Response to Planning application from Hertfordshire County Council (T and CP GDP Order 2015)

District ref: 6/2022/1943/FULL
HCC ref: WH/13629/2022
HCC received: 9 March 2023
Area manager: Matthew Armstrong
Case officer: Senober Khan

LAND BETWEEN 48 & 50 THE RIDGEWAY CUFFLEY EN6 4BA

AMENDED PROPOSAL
Erection of a new dwelling with associated landscaping works

Title Vehicle access and visibility splay

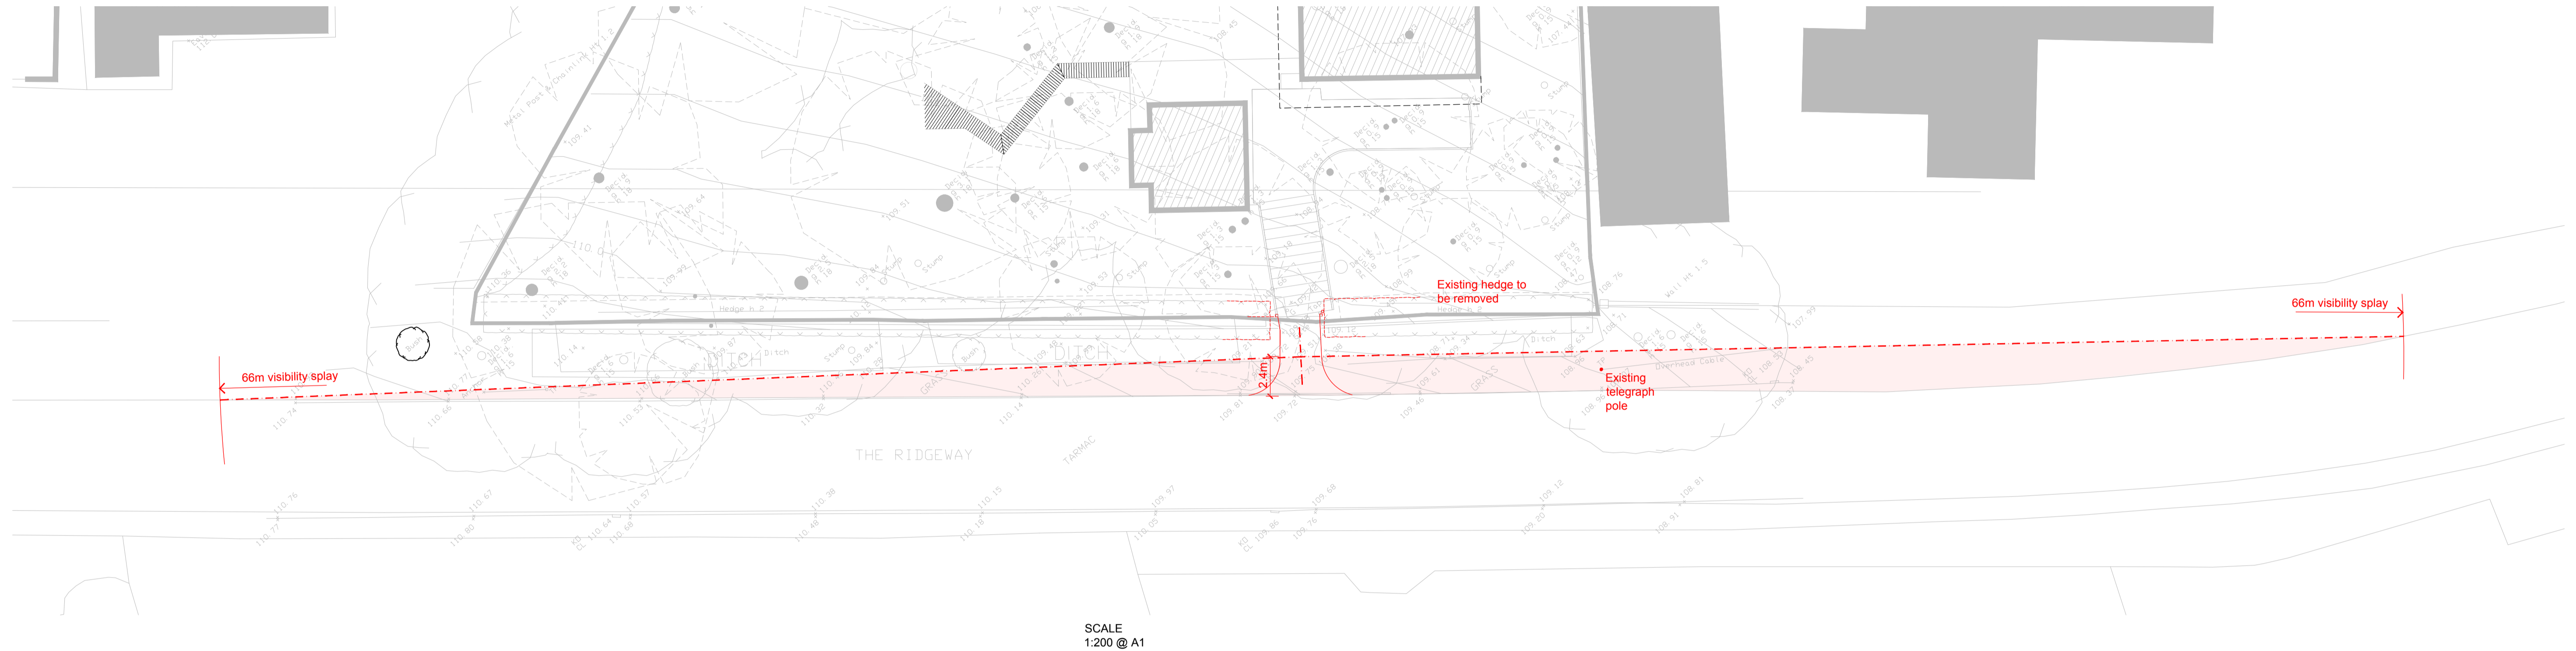
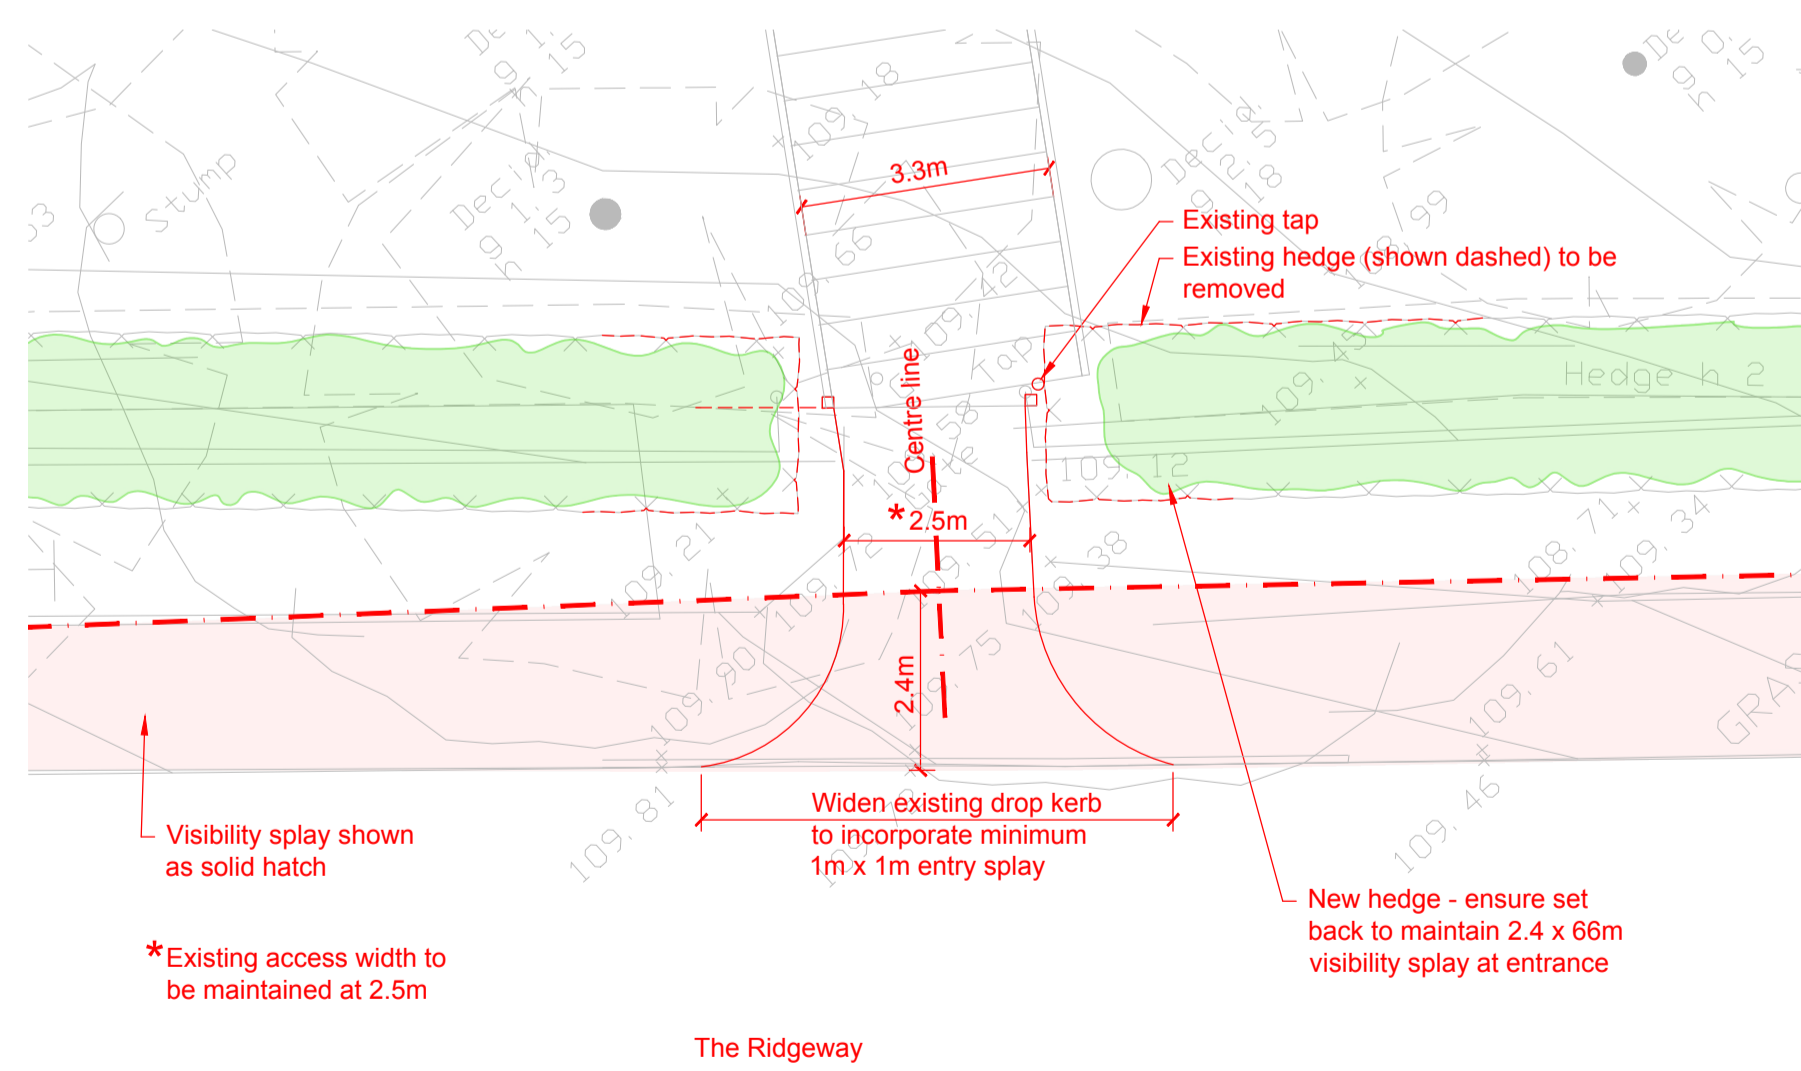
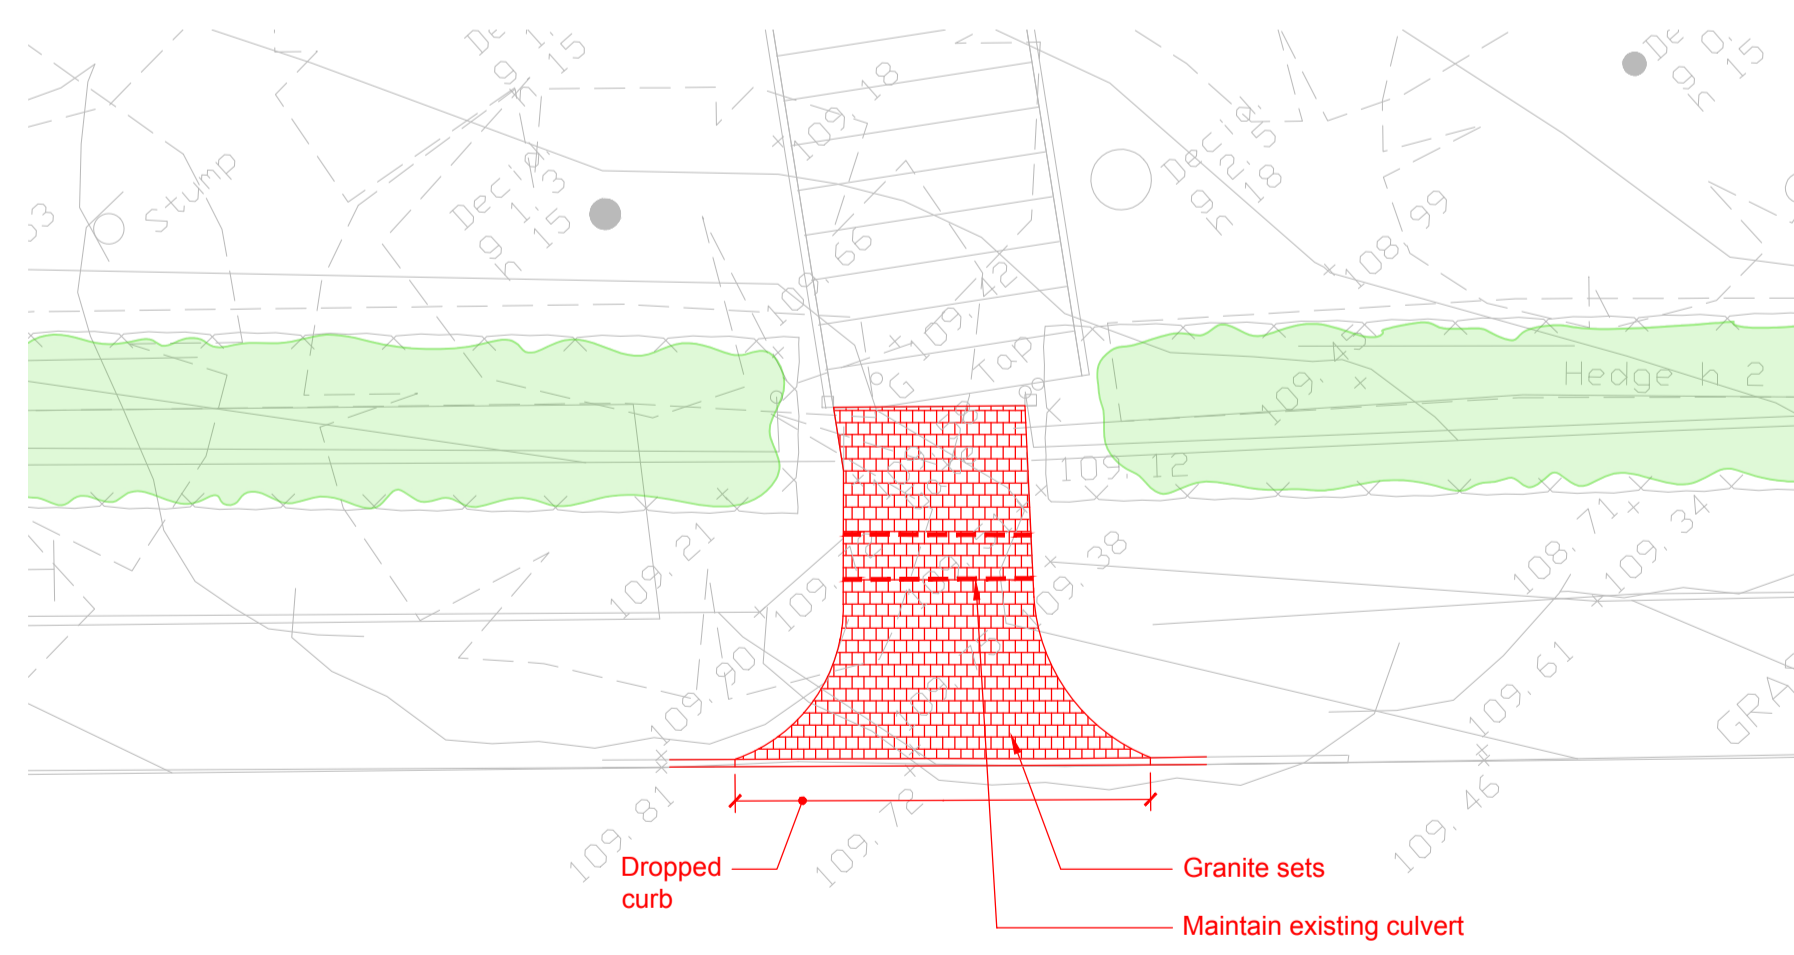
The Site Plan needs to demonstrate that adequate visibility splays if 2.4m x 66m can be achieved.

The design of the vehicle crossing needs to be clarified. It is currently a dropped kerb but is shown on the plan as a bell-mouth. Thirdly, there is no information about whether the ditch is currently culverted at this point and what works will need to be undertaken to ensure the ditch remains free from obstruction.

Whilst the applicant has answered the HA’s question concerning the ditch/culvert however no clarification has been provided regarding is the vehicle access a dropped kerb or a bellmouth, the HA would recommend that the vehicle access be a dropped kerb.

Whilst the above addresses the reasons for refusal given by the HA, however in the plan submitted for the visibility splays a gate is now shown, the HA will not support a gate because given the distance of the proposed gate from the back of the highway, vehicles waiting for permission to be granted to access the site or for the gates to open would obstruct vehicle traffic along the B157 (The Ridgeway), and if denied would have to reverse out onto The Ridgeway from a driveway with a gradient.

Therefore, the HA would not support the siting of a gate at the proposed location without the provision of a turnaround facility.
